Our ref: MP 08\_0064  
File: S08/00646

**Director General's Requirements for a Project Application for the proposed redevelopment and expansion of The Museum of Contemporary Art, Sydney MP08\_0064**

Application number	MP 08_0064
Project	Project Application for redevelopment and expansion of the Museum of Contemporary Art (MCA).
Location	Lots 20, 21, 22 and 23 in DP 787906, 140 George Street, The Rocks
Proponent	MCA
Date issued	25/8/08
Expiry date	2 years from date of issue
Key issues	<p>The Environmental Assessment (EA) must address the following key issues:</p> <ol style="list-style-type: none"> <li><b>Relevant EPI's, Policies and Guidelines to be addressed</b>  Planning provisions applying to the site, including permissibility and the provisions of all plans and policies including: <ul style="list-style-type: none"> <li>SEPP (Major Projects) 2005 Schedule 2 – Sydney Harbour Foreshore Sites</li> <li>SEPP 55 – Remediation of Contaminated Sites</li> <li>Sydney Regional Environmental Plan (Sydney Harbour Catchment) 2005</li> <li>SEPP (Infrastructure) 2007</li> <li>The Sydney Cove Redevelopment Authority Scheme, including an application to vary the Scheme;</li> <li>Sydney Metropolit

TITLE : BUILDING SITE CONTROL DRAWING Drwg no: **XXXIX-B(2)**  
SYDNEY HARBOUR FORESHORE AUTHORITY

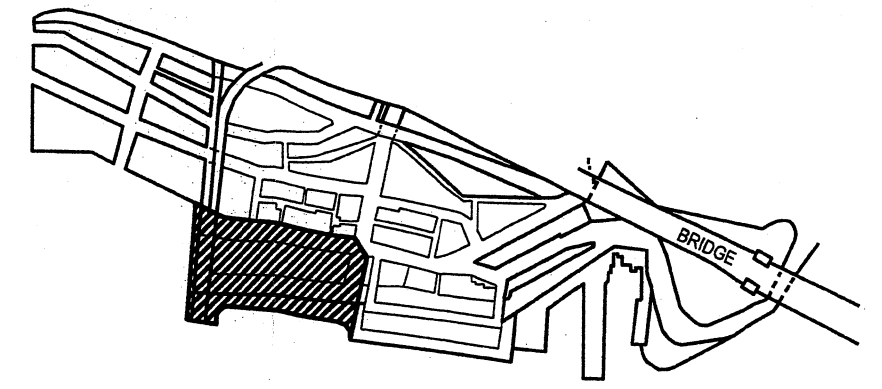
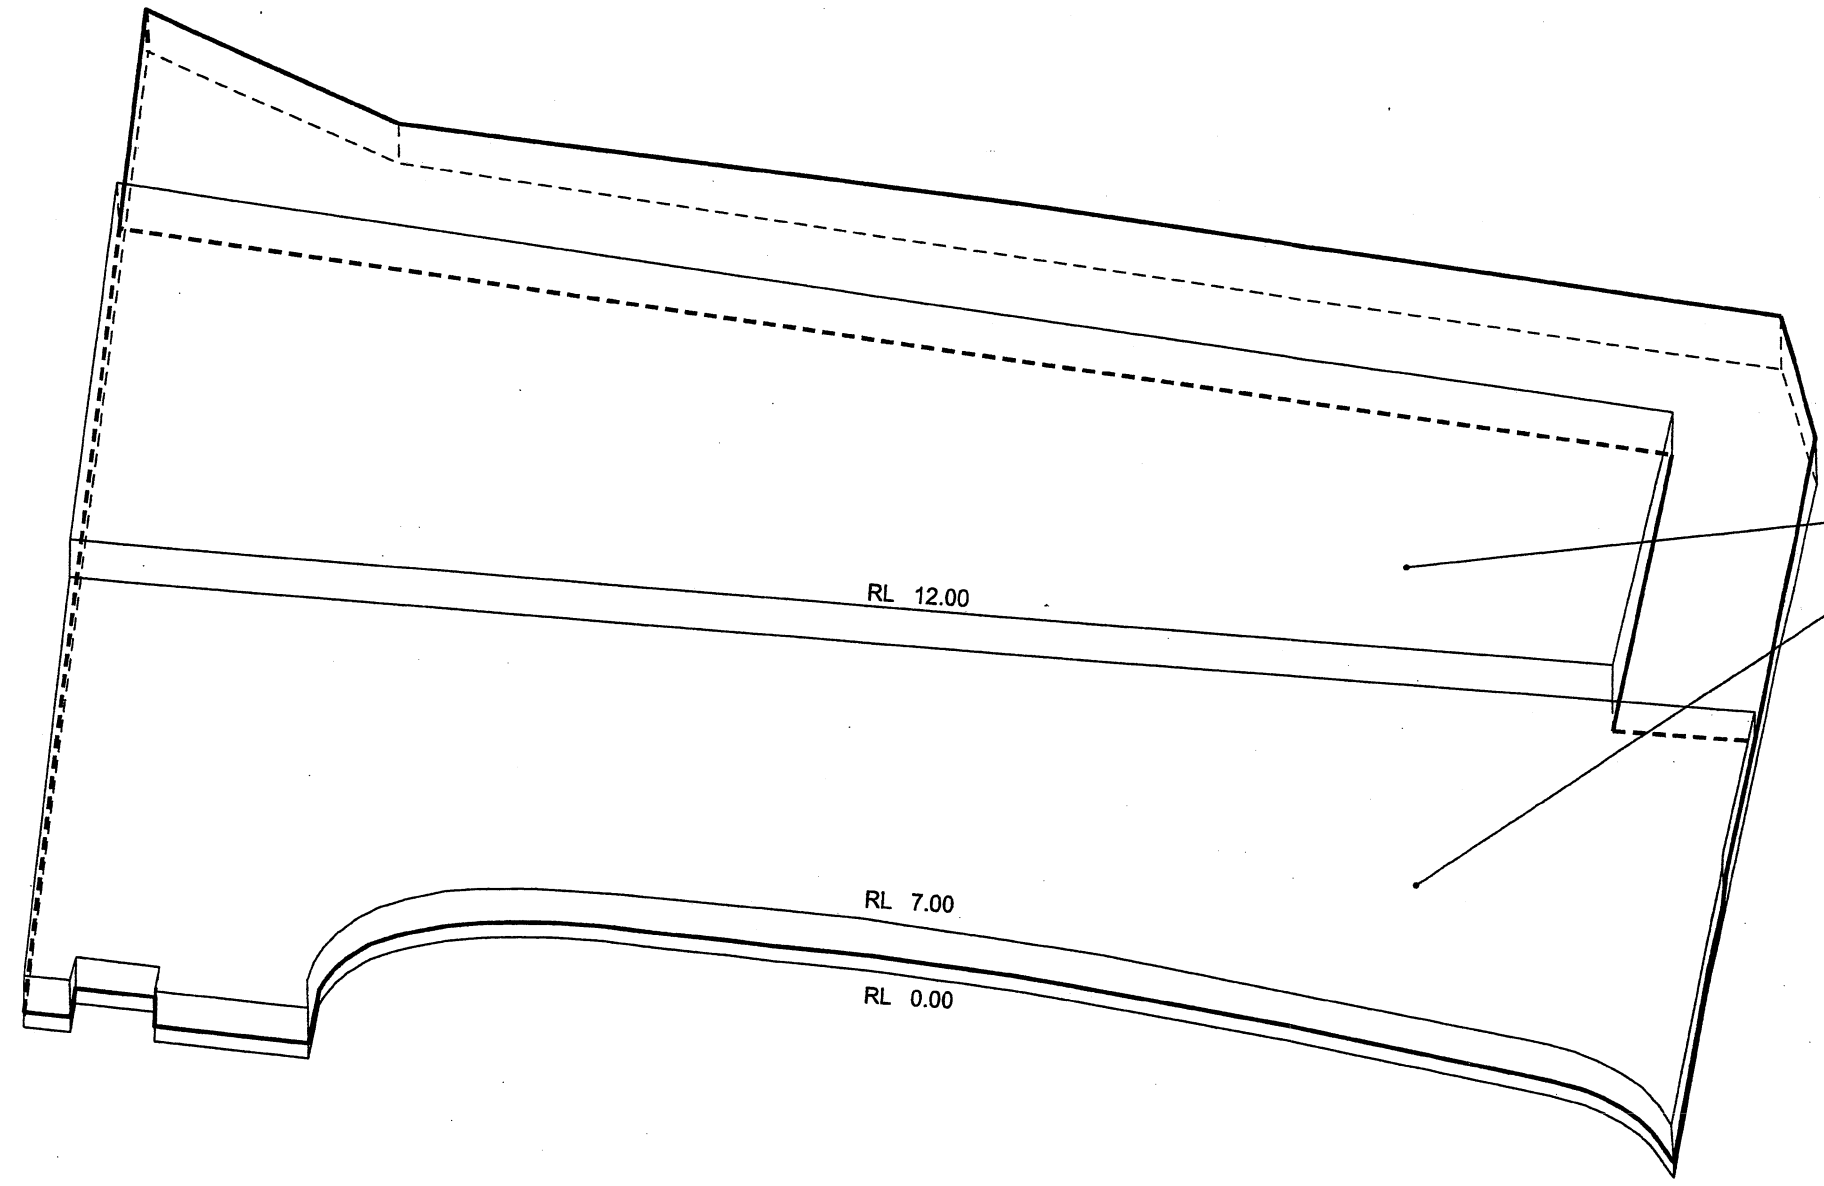
The existing SCRA scheme drawing XXXIXB(i) envisaged that the Old Maritime Services Board (the current MCA) building would be demolished and Lots 20 -23 DP 787906 would be developed as open space, and the maximum RL for the site is 12 m. The proponent will therefore need to lodge an application for a variation to the SCRA scheme, which can be assessed concurrently with the EA. The variation will need to address the whole area covered by this site control drawing, proposed appropriate height limits and other built form controls, and this needs to be developed in close consultation with the Authority.
